**RE: 2019-492 Jindera Solar Farm (SSD 9549) - Notice of Exhibition**

Thank you for referring to TransGrid for review.

Fence cross section
1-1

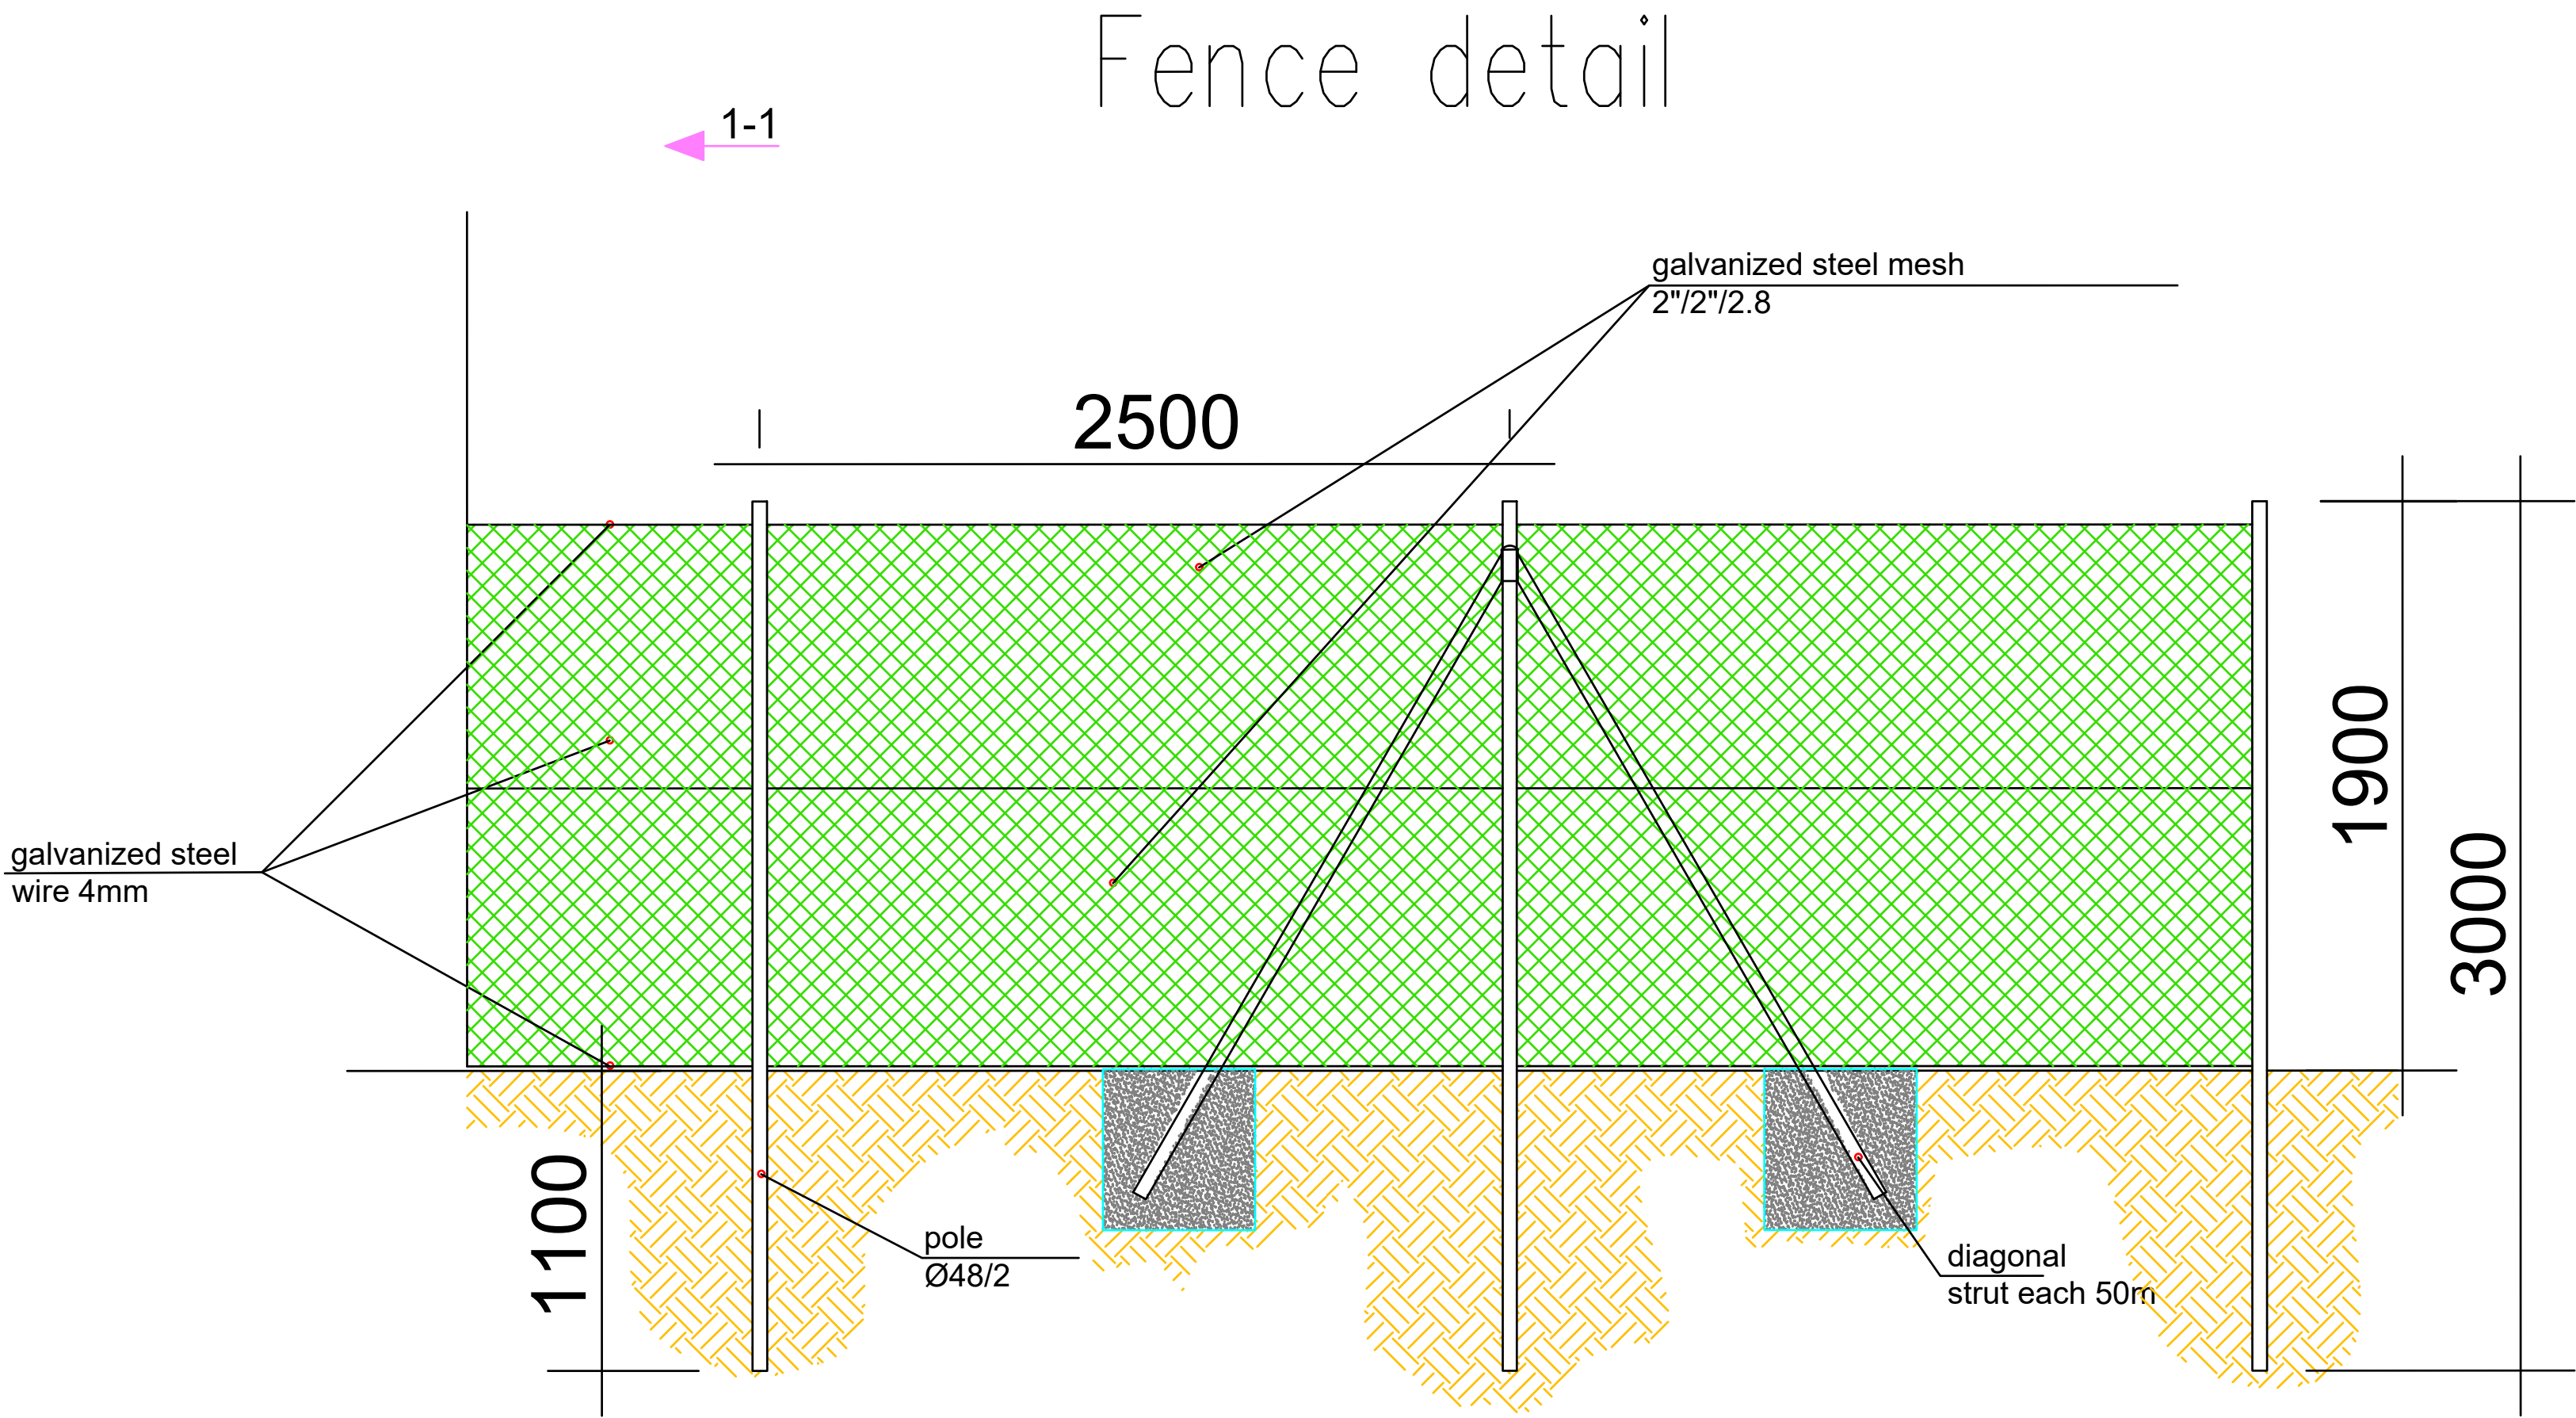
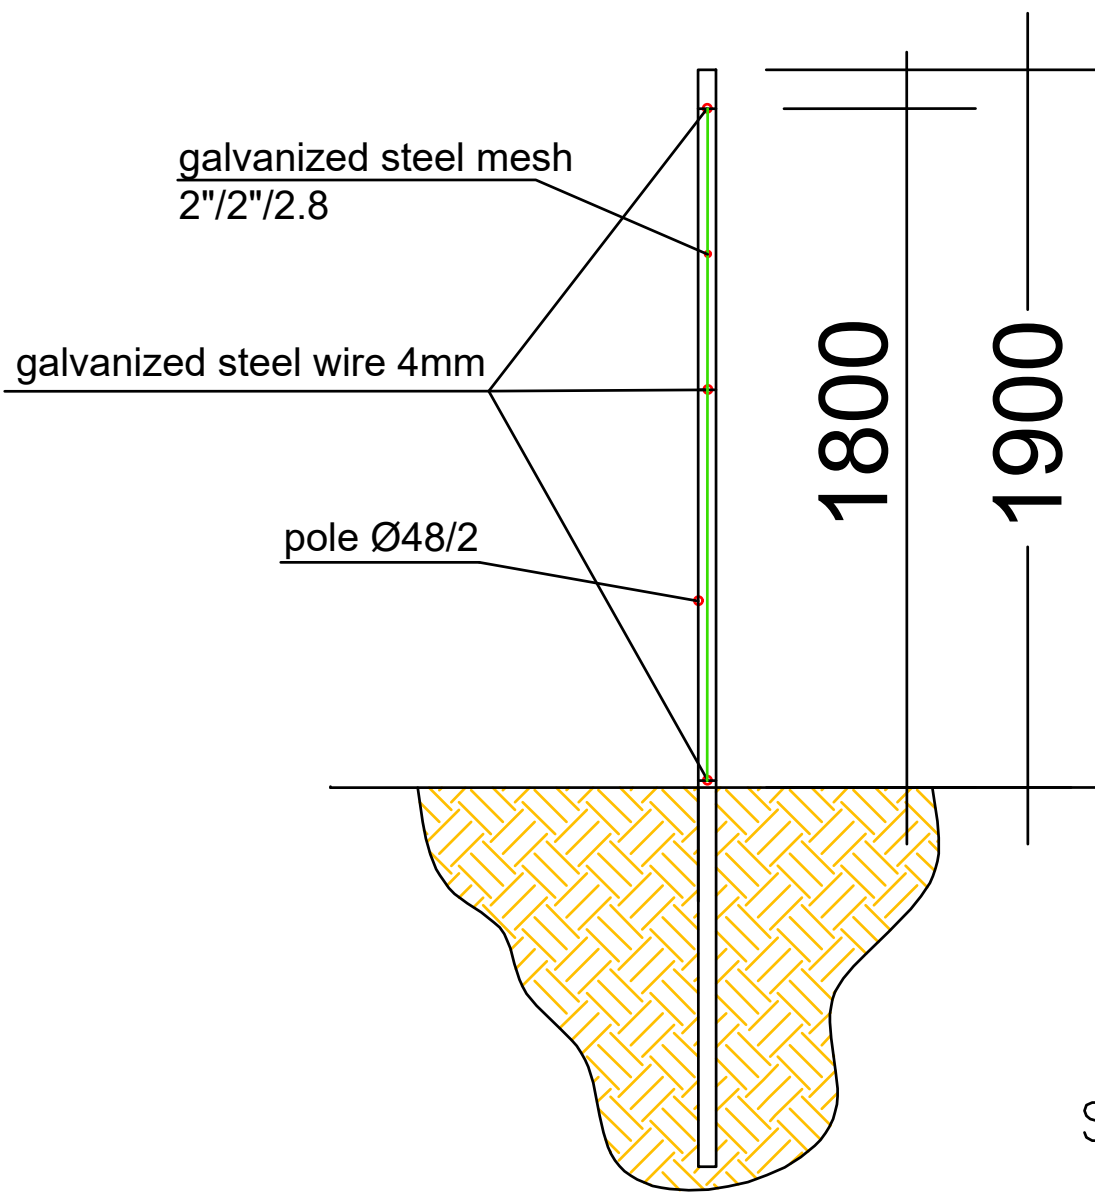
- The following conditions are placed for the Fences:
  - As per the TransGrid Fencing Guidelines, fences parallel to a transmission line outside the easement:

- Metal fence within 10m of the easement must be earthed once in line with each structure and once in the middle of each span.
    - Metal fence within 20m of the easement must be earthed once in line with each structure.
